**Ingleburn Resource Recovery Facility (SSD 8593)
Response to Submissions**

Attachment 1: Additional Information

Bulk Recovery Solutions Pty Ltd – Ingleburn Facility – SSD 8593

VEHICLE TURNING PATH
HEAVY RIGID VEHICLE (12.5m) INTERNAL DROP OFF
16 KERR ROAD,
INGLEBURN
BRS

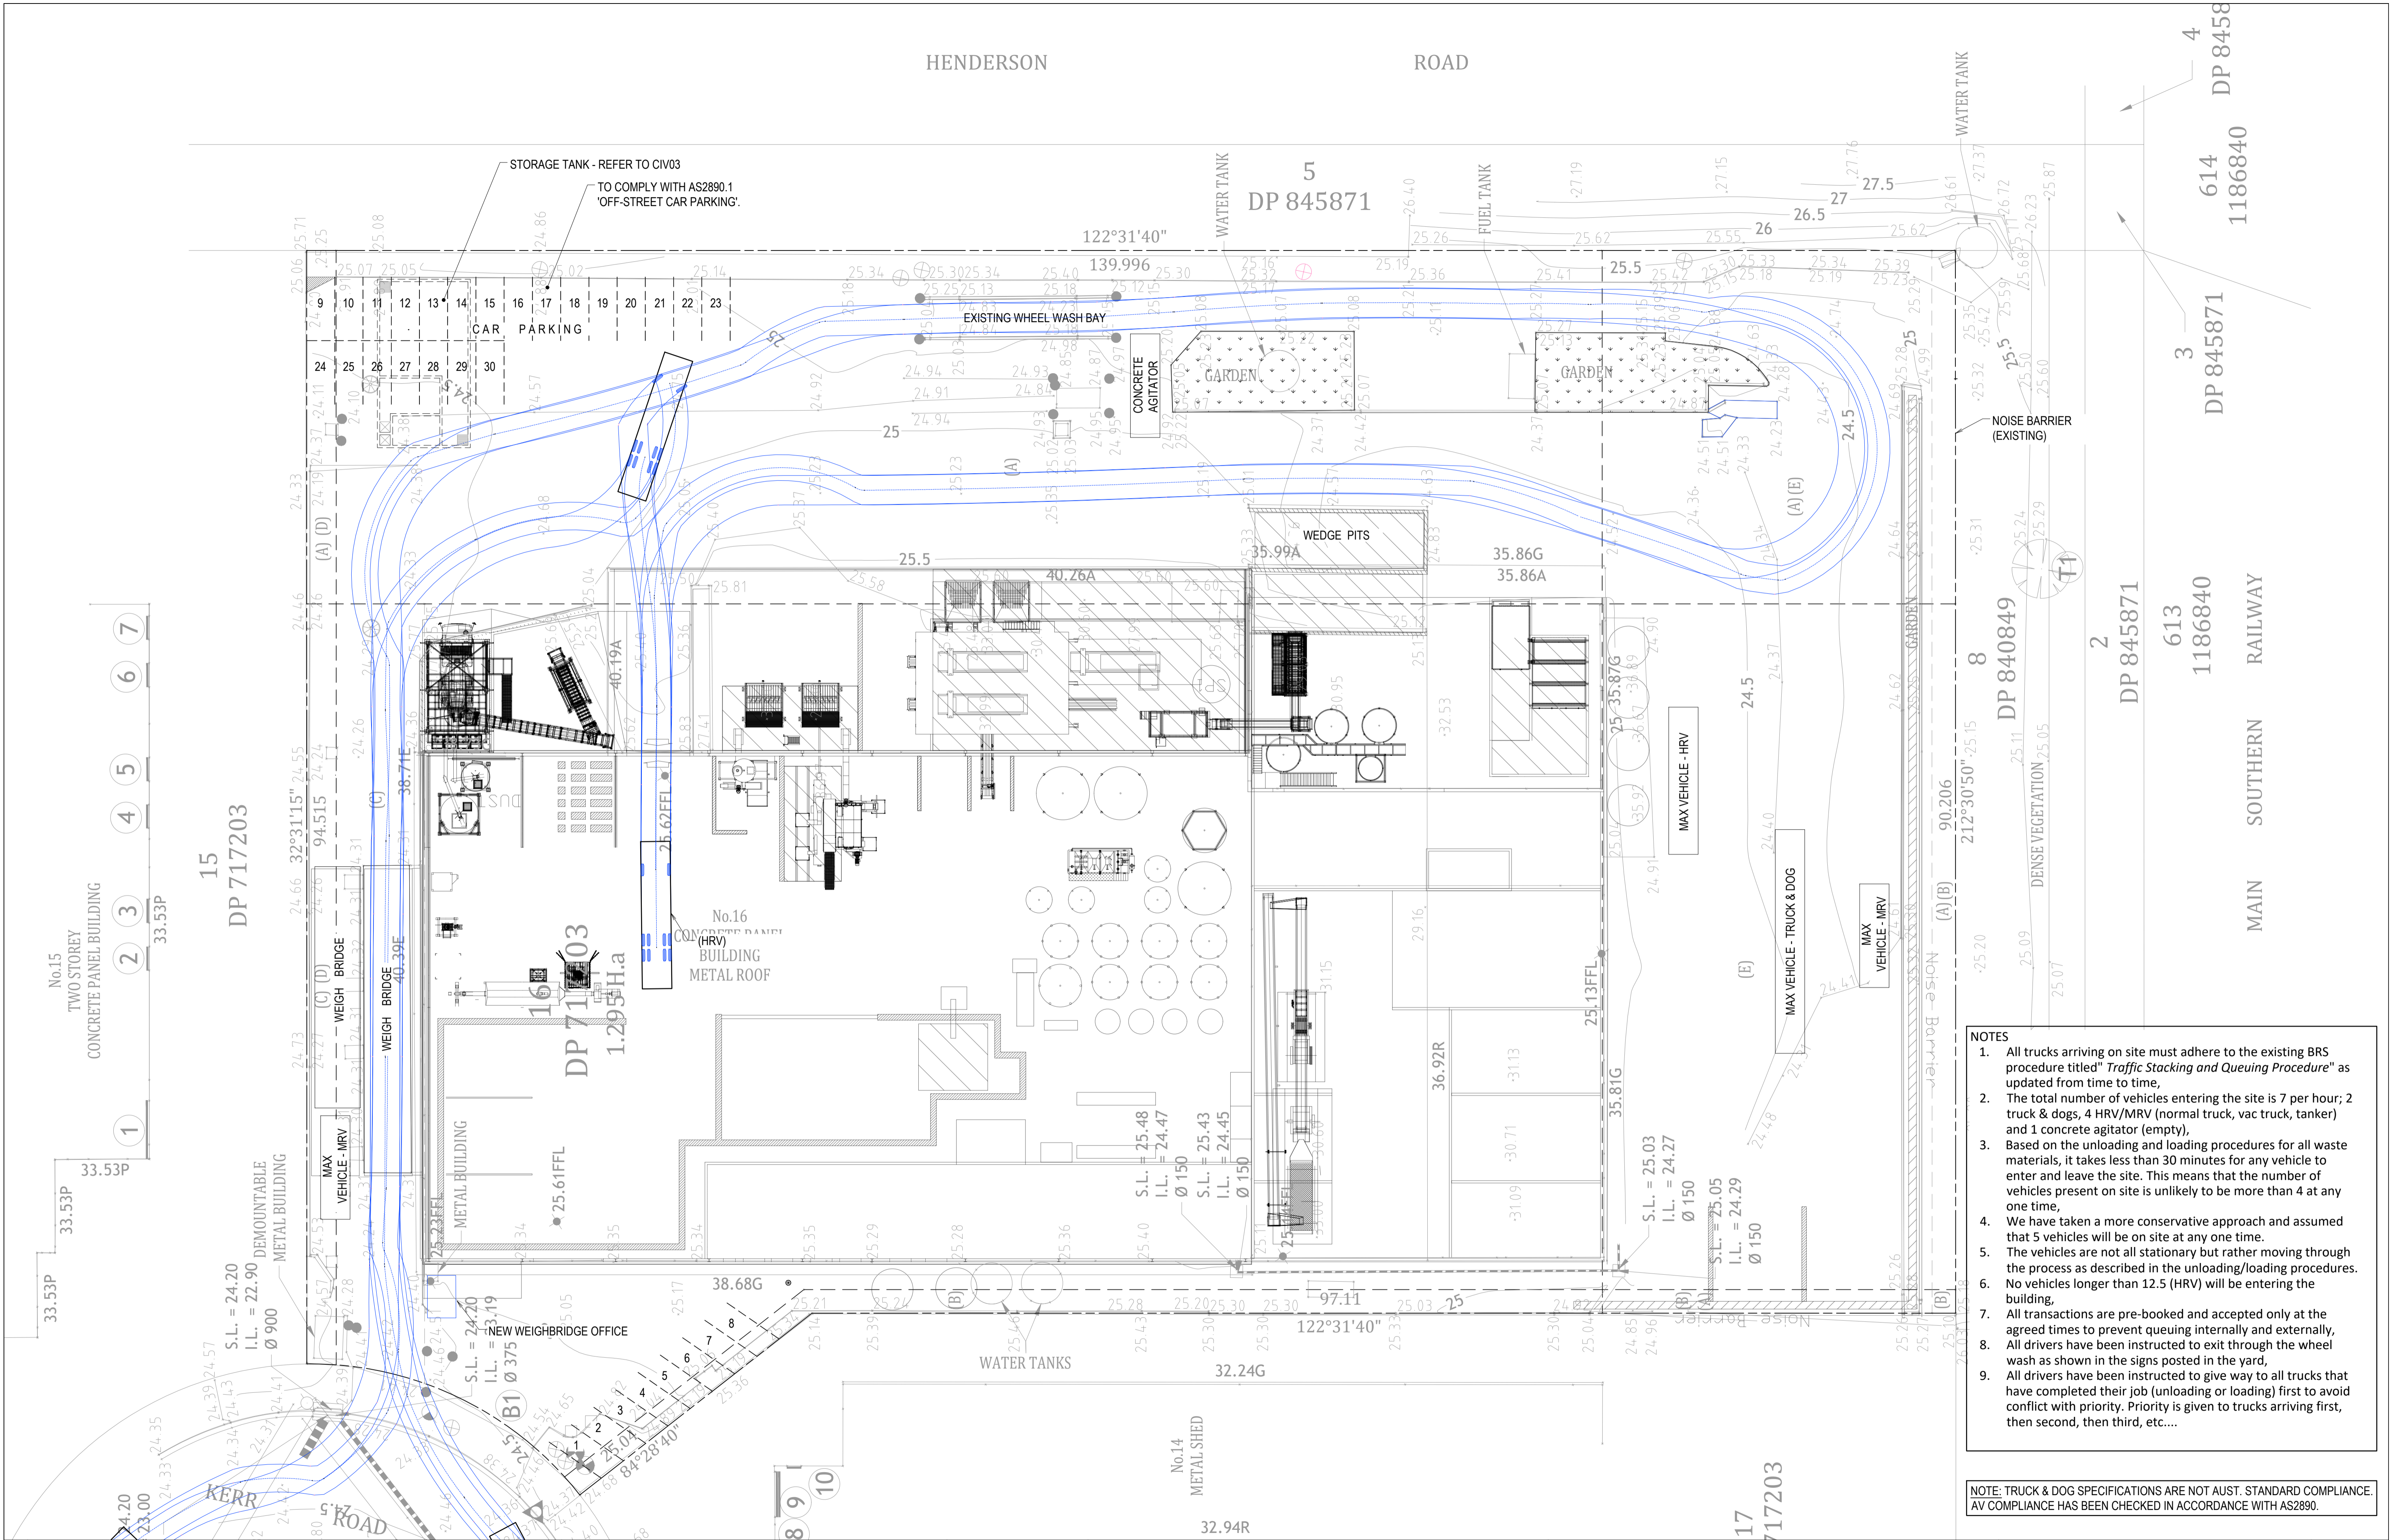
- The temporary storage area (solid materials, skip bins and solids for transfers) and staff parking area appears to be located in the heavy vehicle turning path for B double, articulated vehicle paths and mud waste and smaller trucks. Provide details on how heavy vehicle will be managed and updated plans that show that heavy vehicle safely manoeuvre within the site and the relocation of the receivals area.

- The parking bays appear to be in very close proximity to the vehicle turning path for the concrete agitator. Provide details of how heavy vehicles can safely manoeuvre within the site and not conflict with staff parking.

- The TIA does not assess onsite manoeuvring provide turning path diagrams of all on-site truck manoeuvring is required including:
 - accessing and loading and unloading all stockpiles on the site
